MEMORANDUM

TO: Nell Donaldson, Planner
FROM: David Senus, P.E.
DATE: October 23, 2014
RE: Pamela Road Extension, Final Level II Site Plan Application

Woodard & Curran has reviewed the response to comments for the Final Level II Site Plan Application for the proposed extension of Pamela Road in Portland, Maine. The project involves the construction of approximately 750 feet of new road along a paper right-of-way that was established in 1969.

TYPICAL TRENCH SECTION DETAIL
NOT TO SCALE

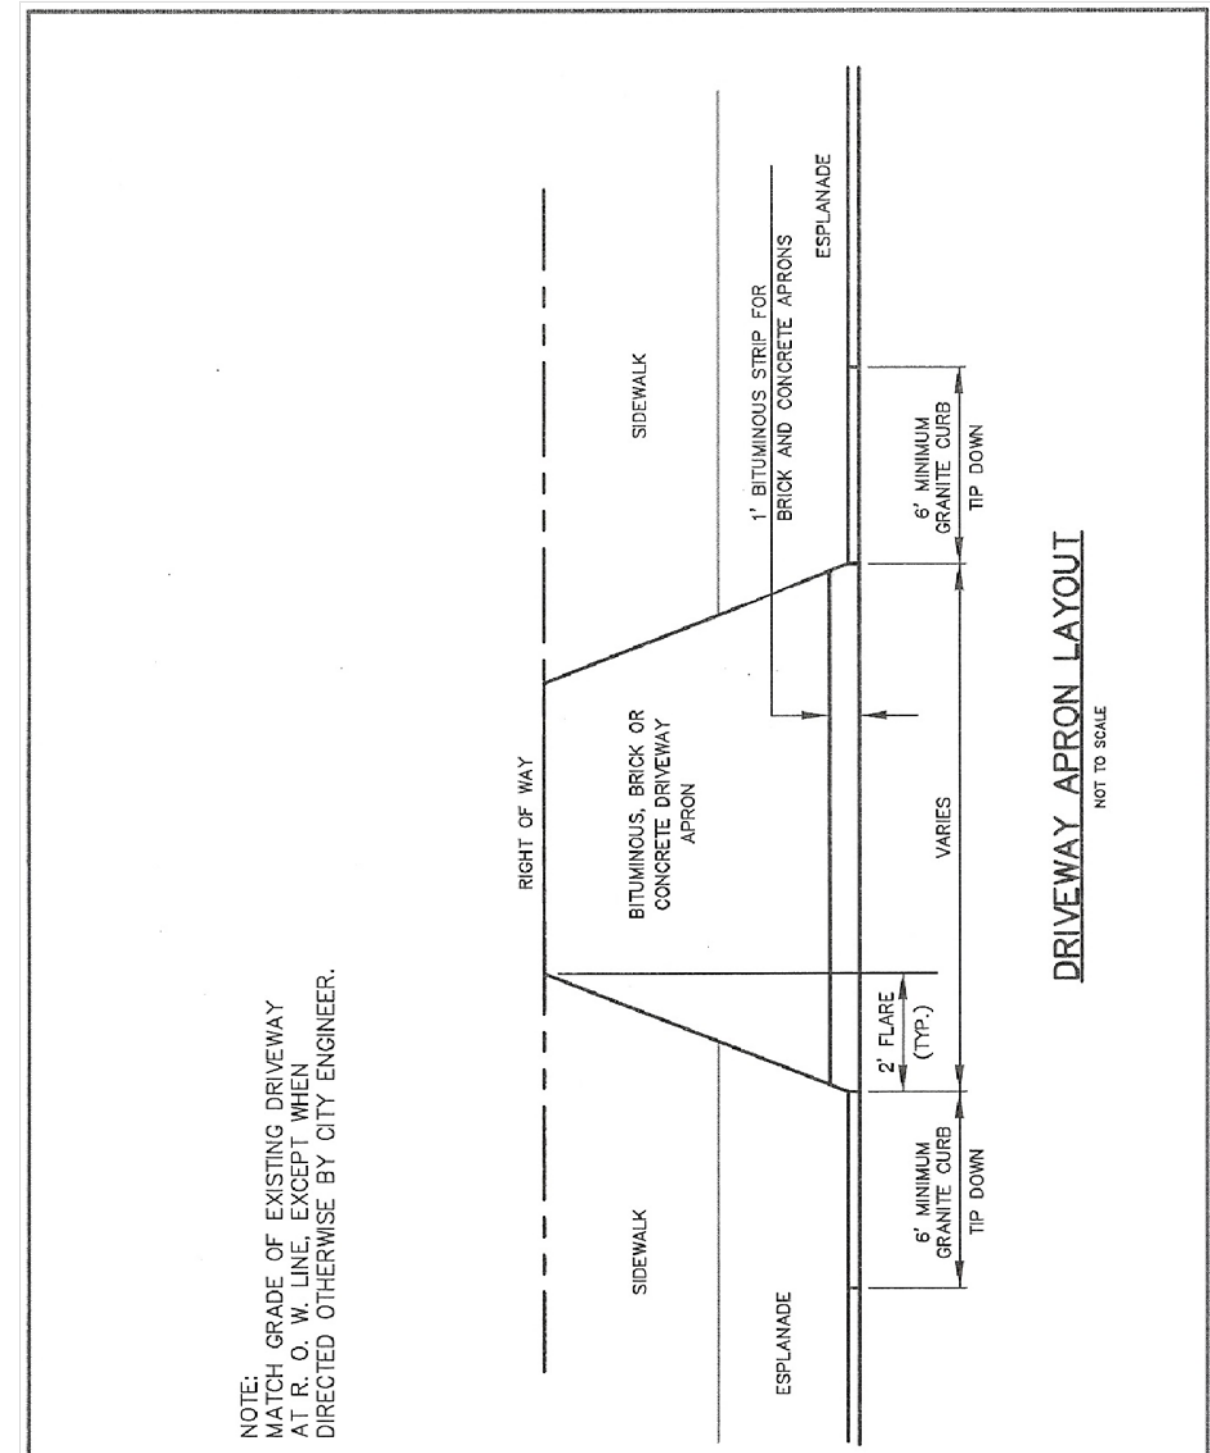
- 5) The "Sewer Trench Section" detail on Sheet 9 is not a City Standard detail and should be deleted. The sewer pipe installation should follow the Typical Stormwater Trench Section Detail on Sheet 8 (and the detail name should be revised to "Typical Trench Section Detail").

Drawing Name:
GRADING & DRAINAGE PLAN

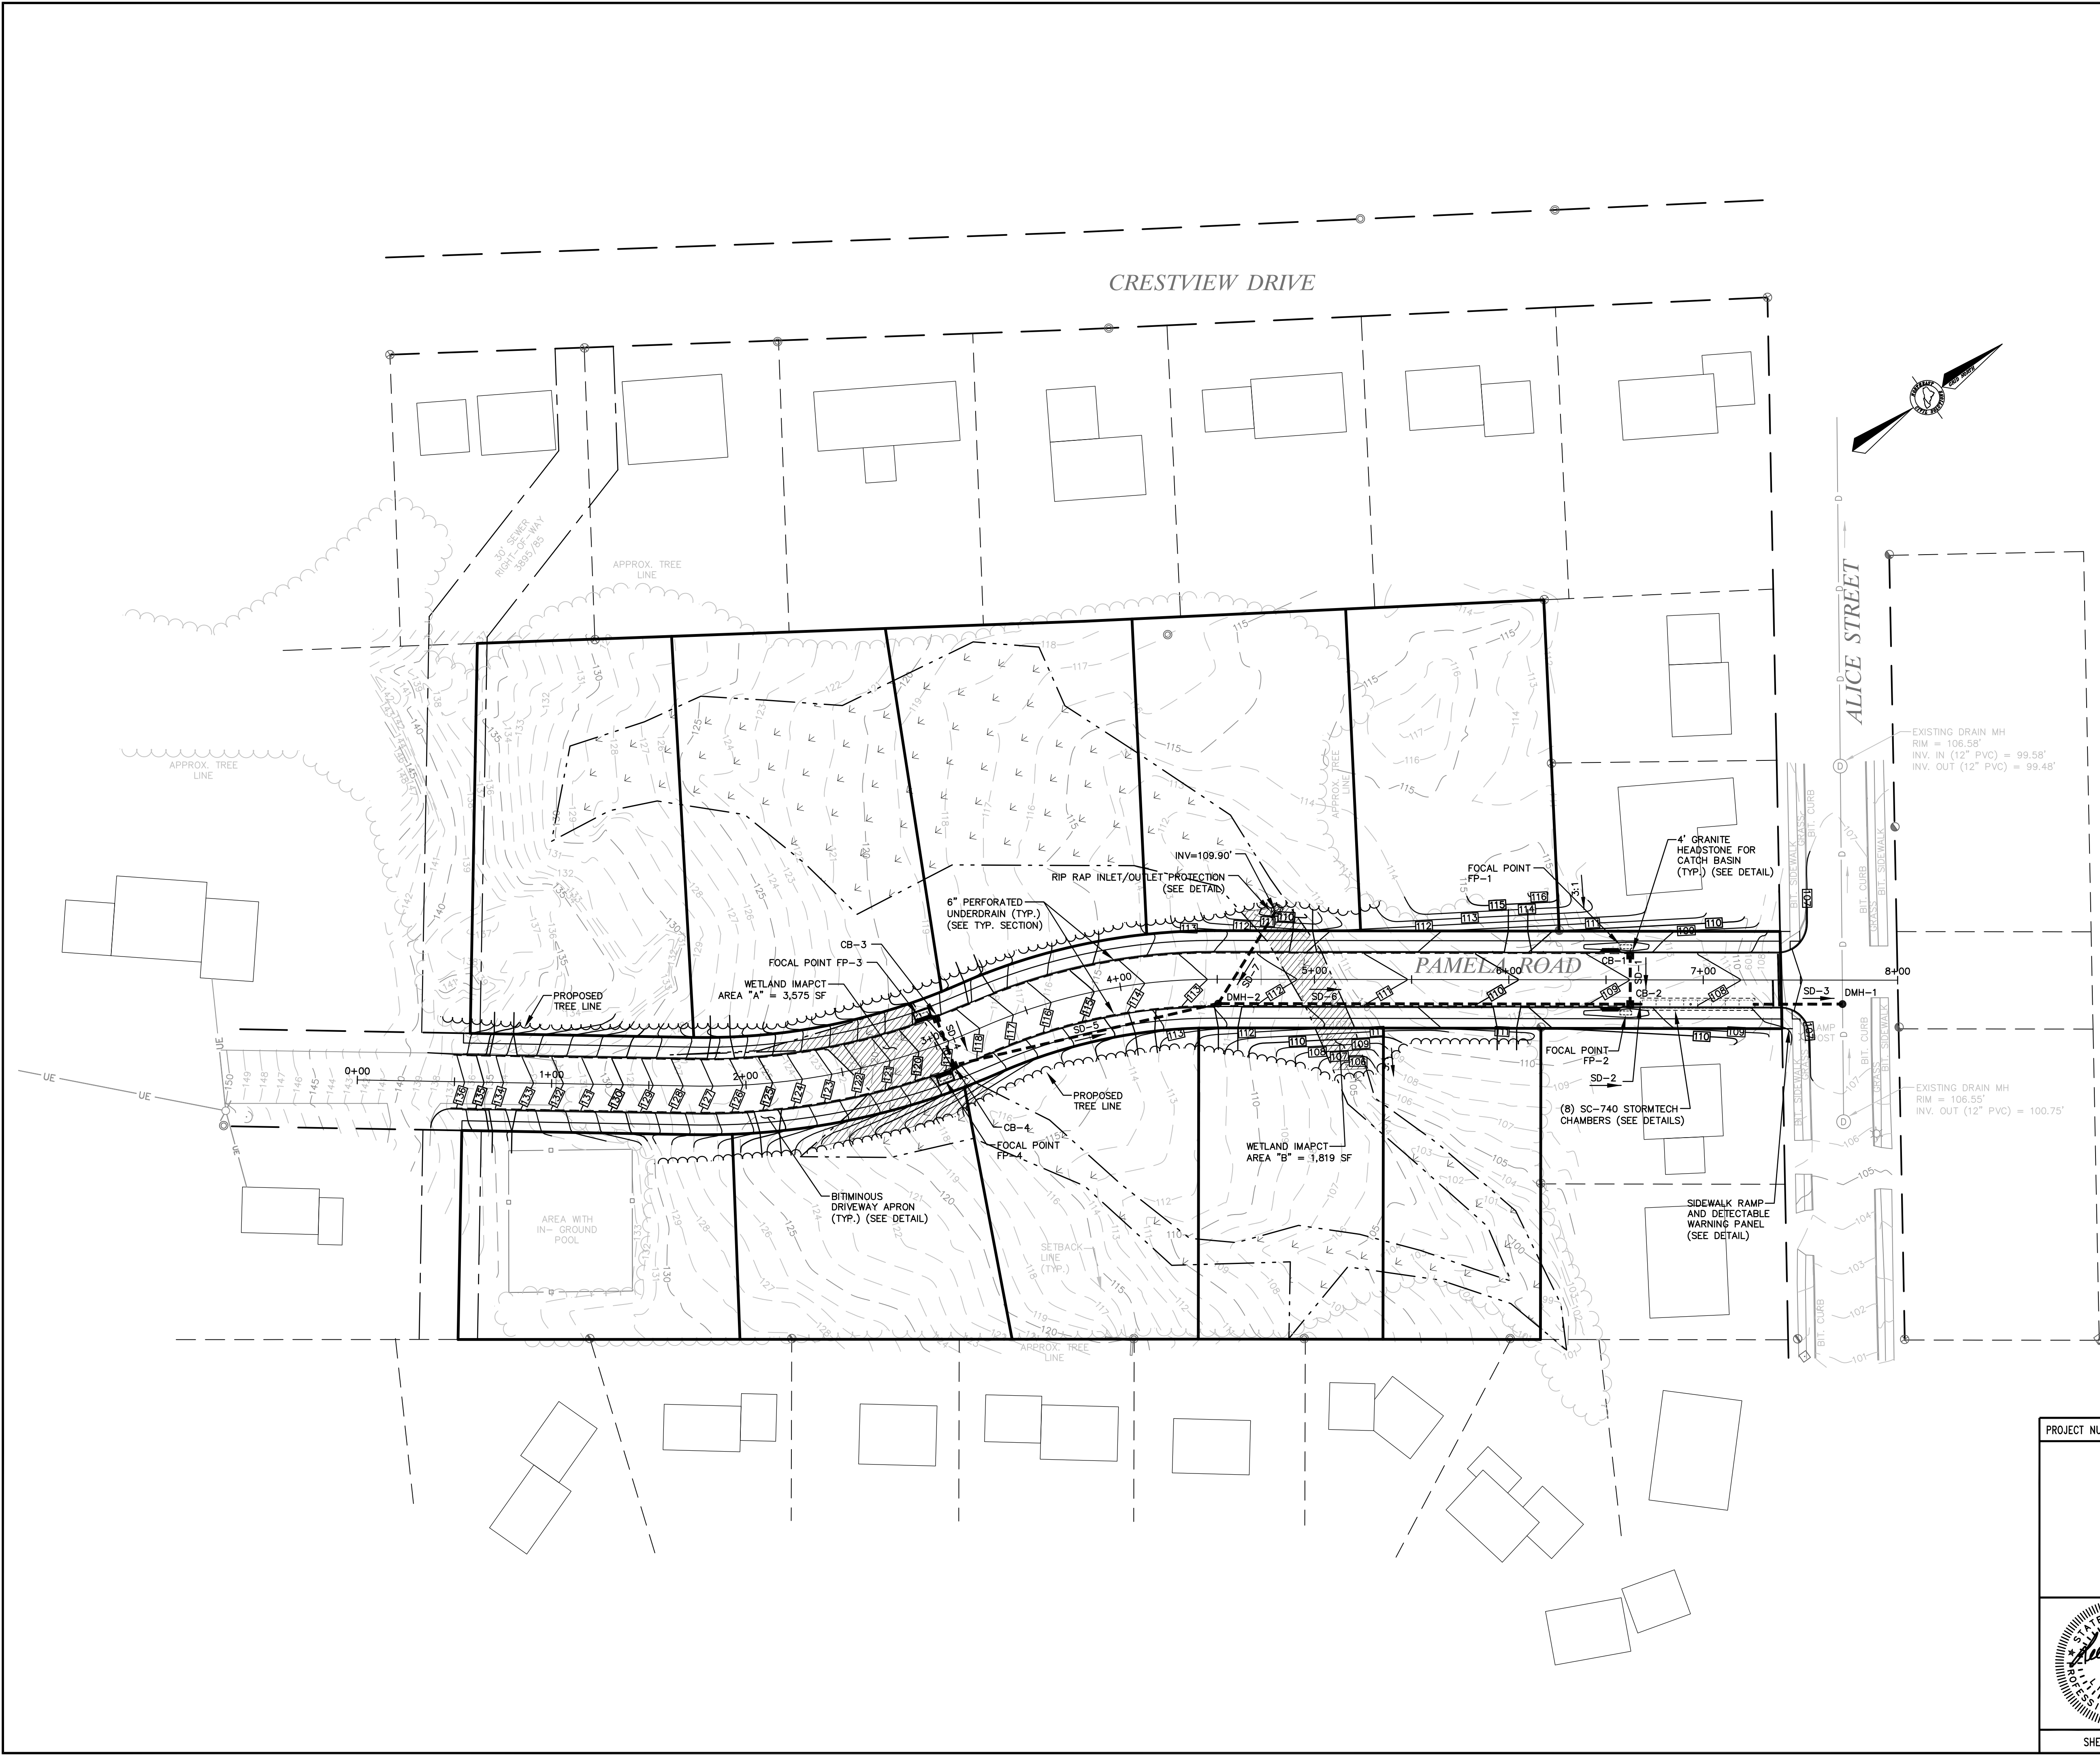
- 4) A cross culvert is necessary at STA 5+00 to allow drainage from the west side of the proposed roadway to drain to the east. The current design would create an impoundment of the wetland on the west side of the road with no outlet. The contributing drainage area west of the proposed roadway should be evaluated to size this cross culvert. We apologize for not identifying this on our initial review.

INFILTRATION SYSTEM #1
SCALE: 1" = 10'

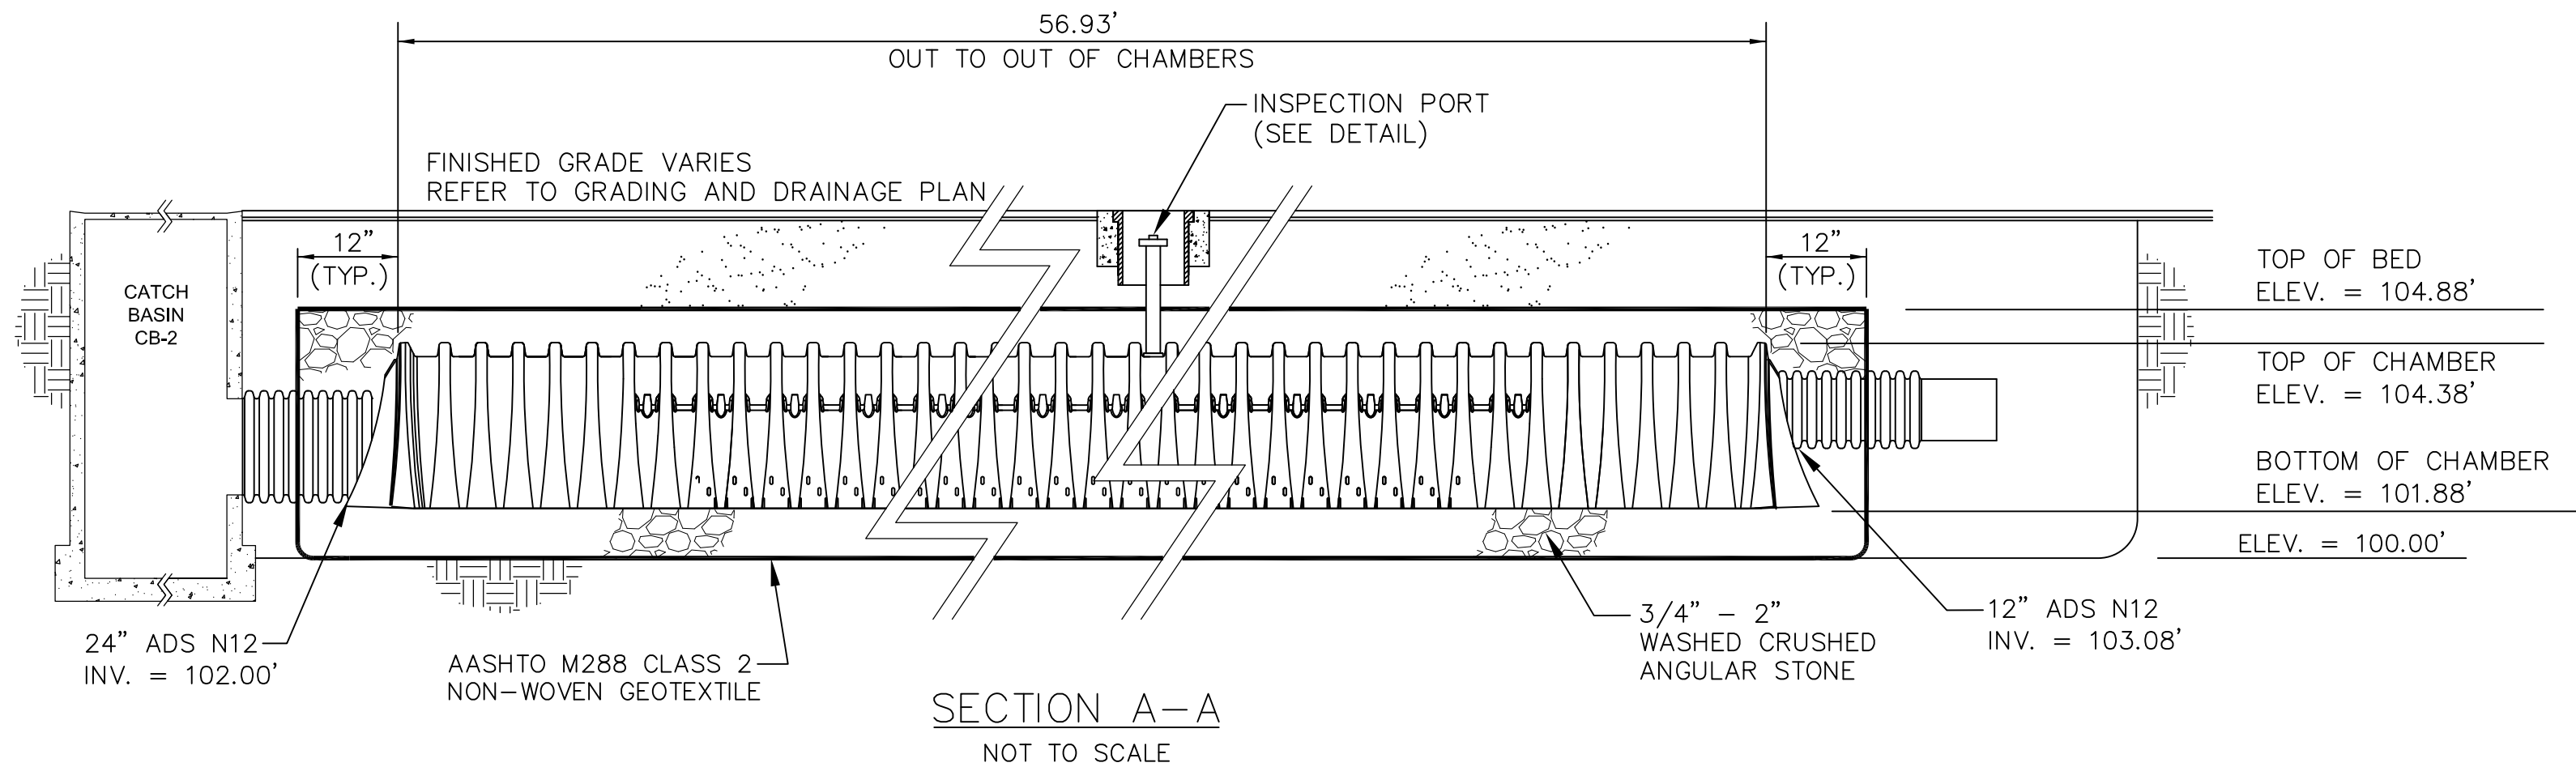
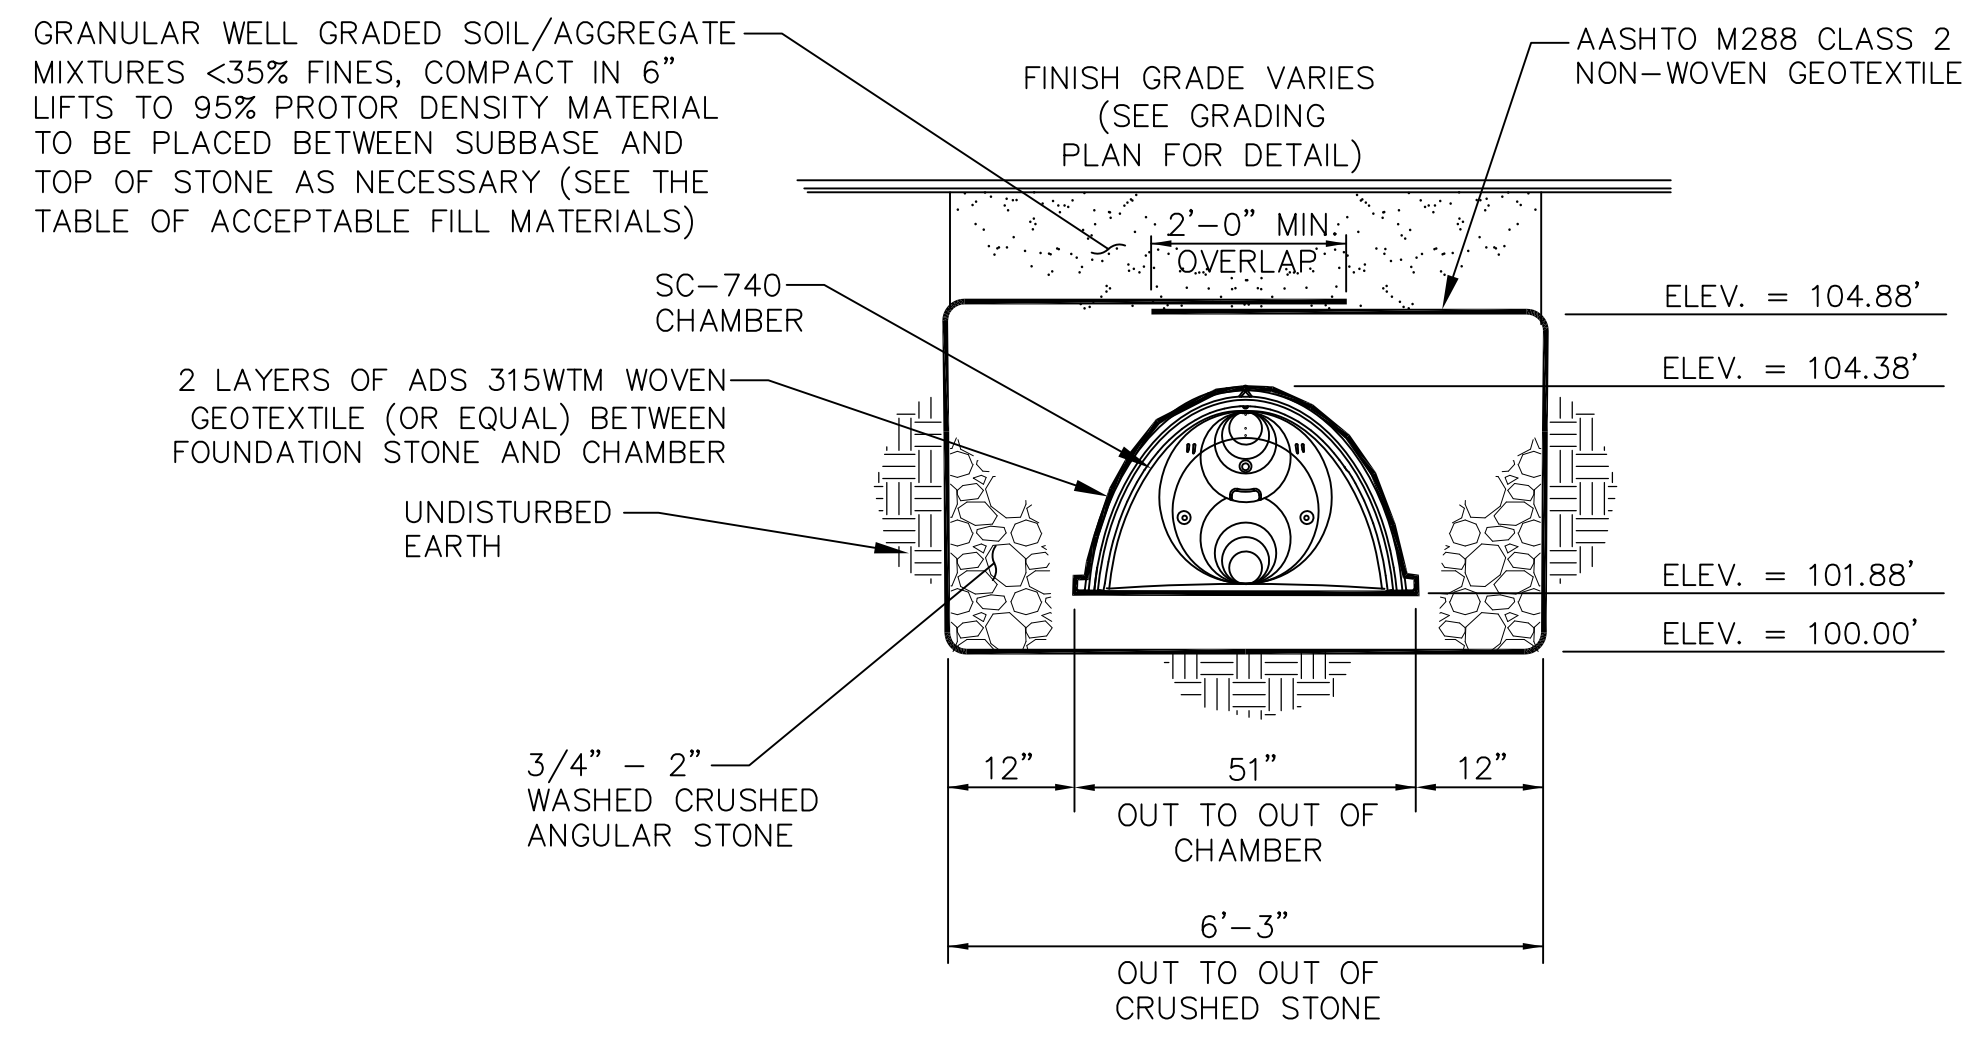
- 3) Two layers of woven geotextile fabric shall be placed between the stone and the Isolator Row chamber (at the interface between the stone and the chamber). As proposed on Sheet 12, the Applicant has shown 2 layers of geotextile between the stone and the surrounding backfill but no geotextile between the chamber and the stone (note: only one layer is required between the stone and the surrounding backfill).
